**Planning Committee**

**12 March 2020**

**CHERWELL DISTRICT COUNCIL  
PLANNING COMMITTEE  
12 March 2020**

### **8. 19/02550/F Land e/o M40 and s/o A4095, Chesterton *Additional Consultation Responses and Representations received***

Middleton Stoney 1803047-17C.pdf

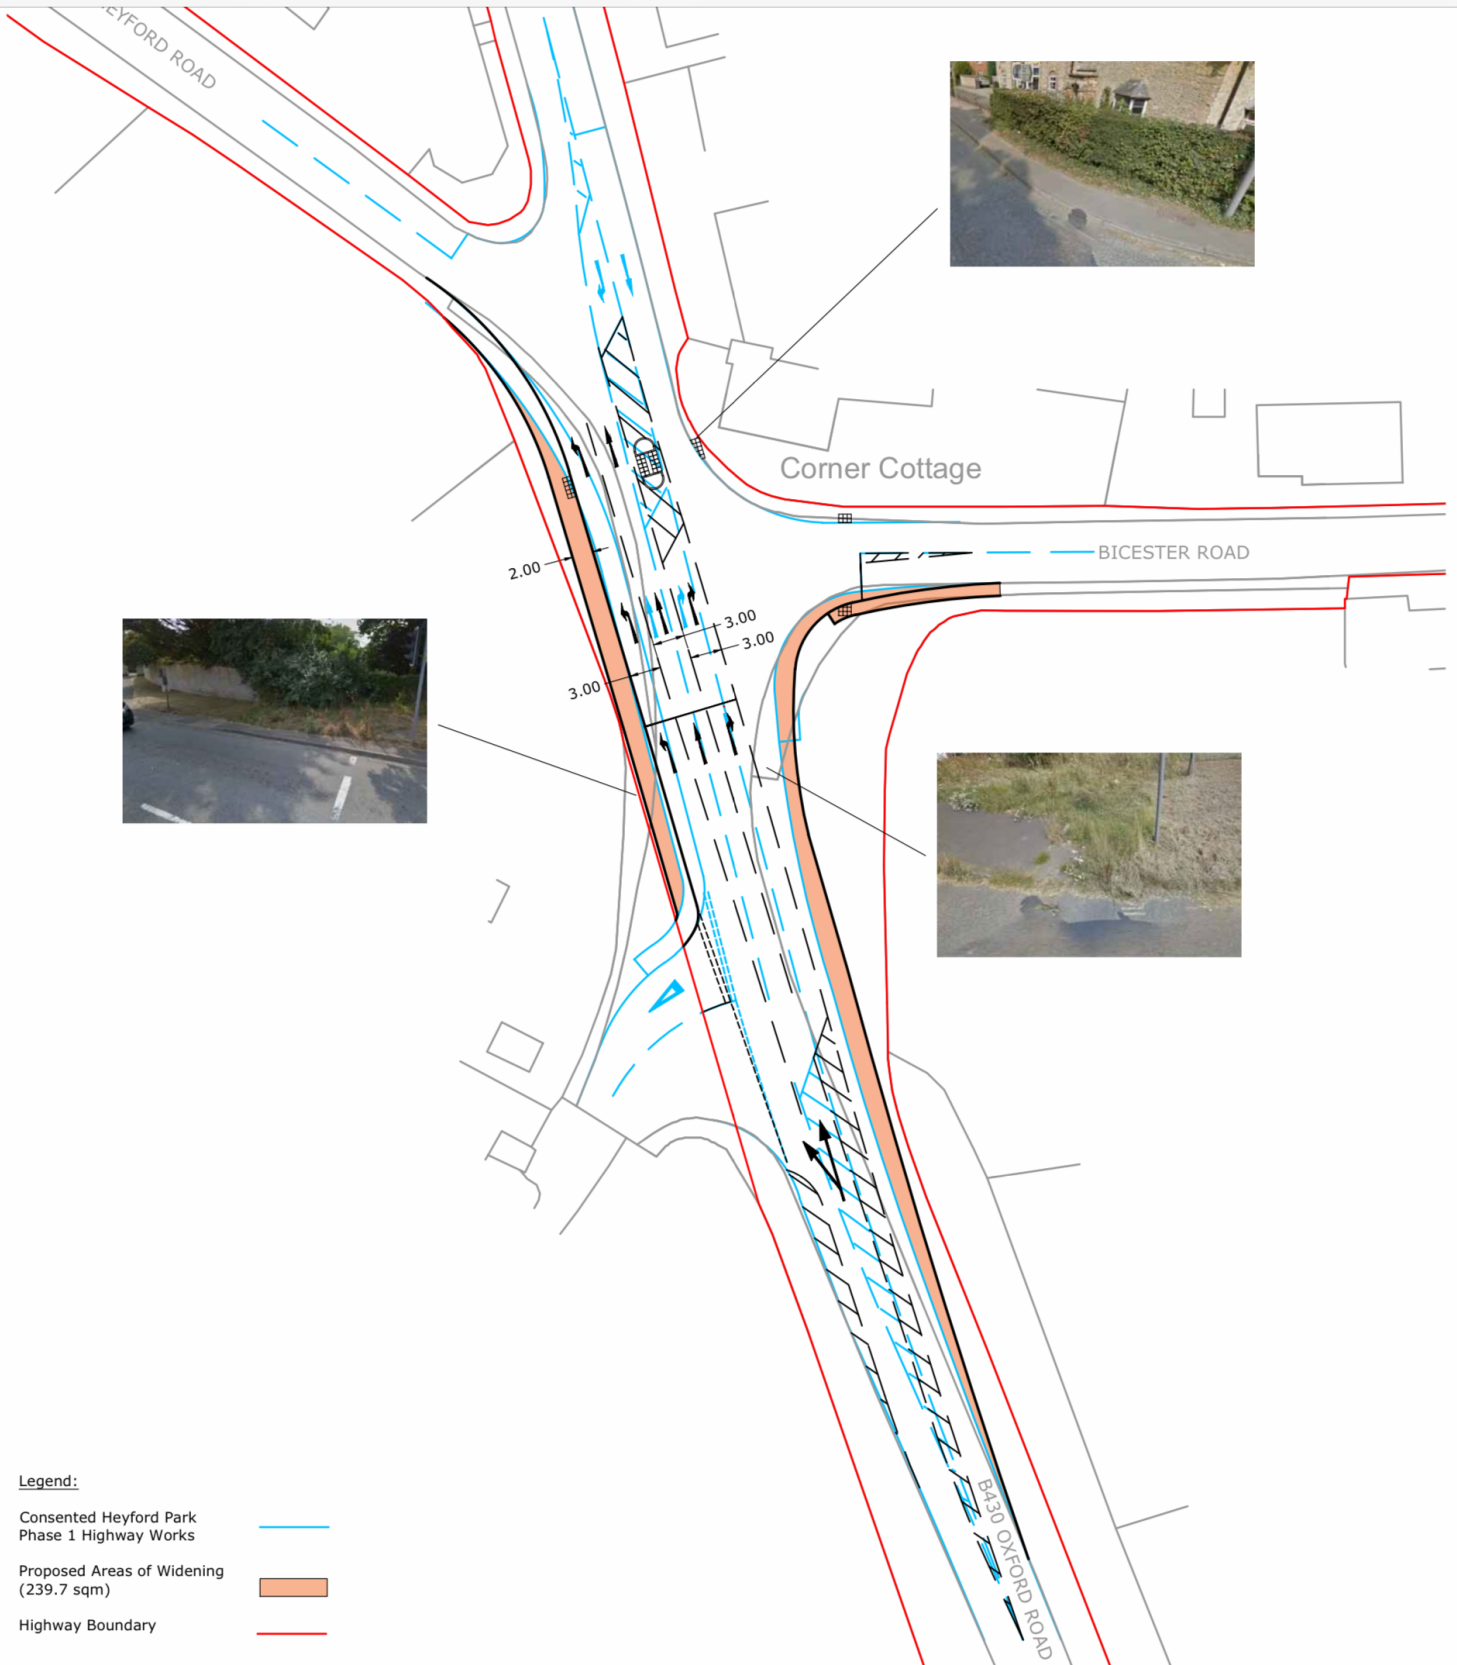
**Oxfordshire County Council Highways – OBJECTION** The following comments have been received in respect of the updated Indicative Mitigation Works drawing (no. 1803047-17 Rev. A) and accompanying text.

- The single B430 northbound lane opens up to three lanes approximately 35m from the stop line. It is highly unlikely that all straight-through traffic will switch to the centre lane – some vehicles will remain in the left-hand lane (either mistakenly or deliberately) and will, therefore, have to merge back into the northbound flow rather than turning left. These manoeuvres will occur to the north of the junction where the carriageway diverts relatively sharply to the right and where a vehicle (or vehicles) may be waiting in the filter lane/box to turn right into Heyford Road.

- These merging movements carry the risk of side-swipe collisions. Furthermore, they will slow the progress of vehicles through the junction, which is an issue that would not be reflected in the modelling.

- As the majority of vehicles will be heading straight through, it will only take about five or six cars in the centre lane before the left- and right-turn lanes are blocked. The intention of the scheme is to increase capacity by adding the left-turn lane but it is unlikely that sufficient vehicles will be queueing in that lane to make a significant difference.

- We have concerns about the suitability of the east side crossing point. It is acknowledged that the footway is a substandard width at this location (exact width not given) and the carriageway narrows to roughly 2.6m, so it will not be a comfortable place to wait to cross as there will be little clearance for pedestrians from passing vehicles.

- The pedestrian refuge may introduce an obstruction to HGVs and buses moving east-west on the B4030. Swept path analysis for maximum-size vehicles has not been provided.
- OCC would need to see a Stage 1 and 2 Road Safety Audit for this design before considering it further as there are potential safety issues.
- Although not specifically a highways issue, there would be a significant visual impact from the substantial road widening.

In conclusion, we still have significant concerns over the safety of the latest mitigation proposals, and doubts whether the capacity improvements could be achieved. Hence, we are still unable to remove our objection as outlined in our response to 19/02550/F.
